From: Mike Burford
Sent: 15 December 2011 10:23
To: Planningecons
Subject: RE: Planning Consultation on WA/98/11/DOC
Engineers Comment on WA/98/11/DOC:

APPLICATION WA/98/11/DOC
NO:

Registered: 13-DEC-11
Site West Walberton Farm West Walberton Lane Walberton BN18
Address: 0QS

Description of Works: Application to discharge condition number 5 on planning permission WA/59/11

Proposed Floor Plan Showing Soakaways

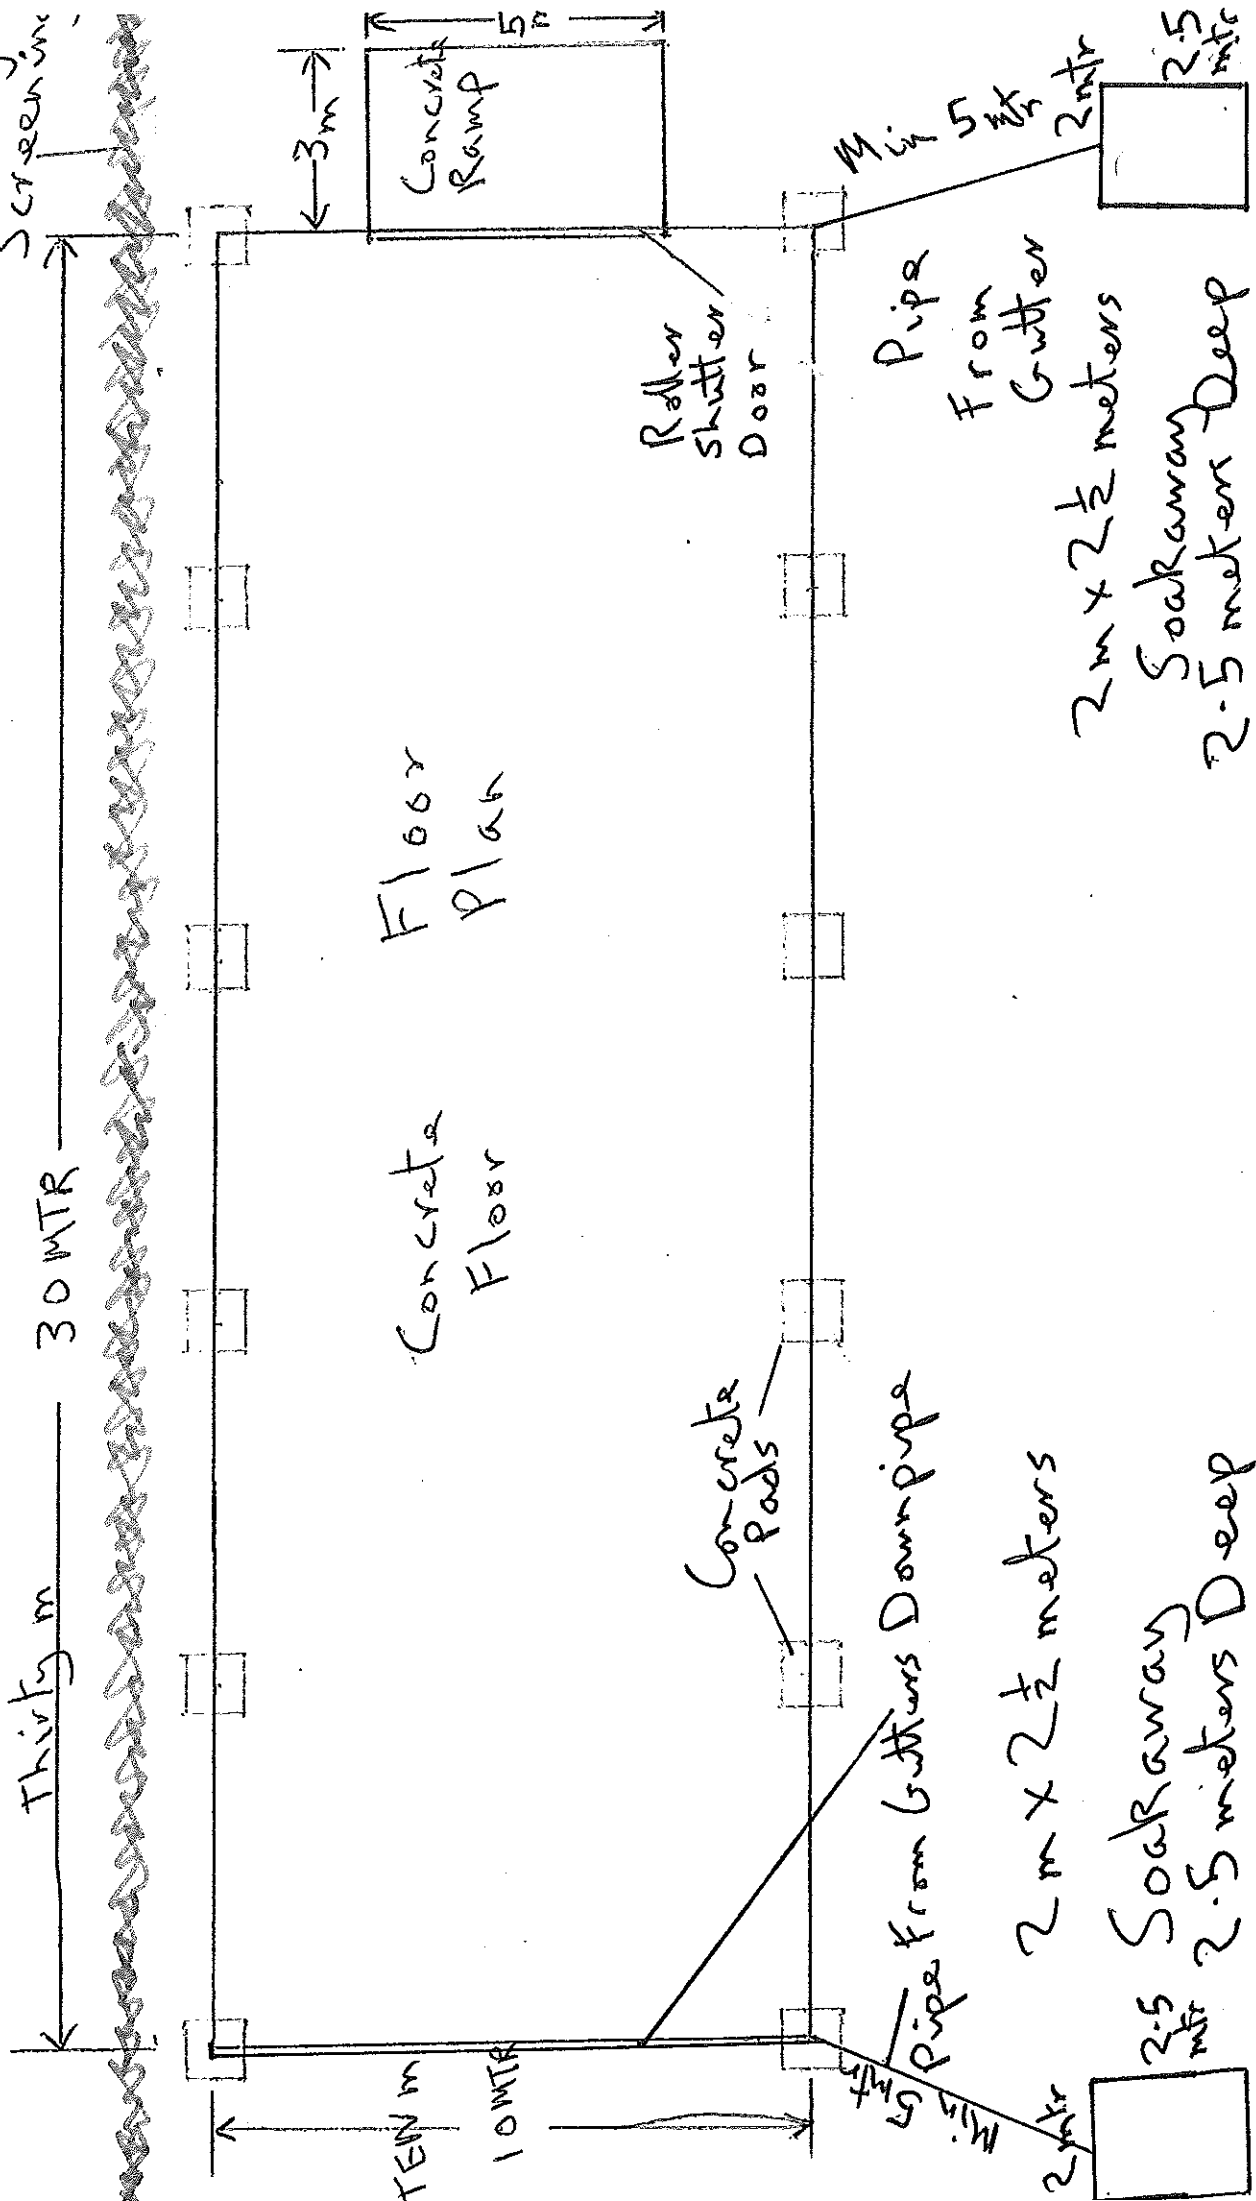
Design requires calculation to BRE365 or similar, with winter ground water monitoring and percolation testing to support.

The base of the soakaway must not be below the ground water table and should store a 1 in 10 year rainfall event below the invert of the pipe and a 1 in 100 year rainfall event plus 30% below ground level.

As the above has not been submitted I cannot recomend the discharge of condition 5.
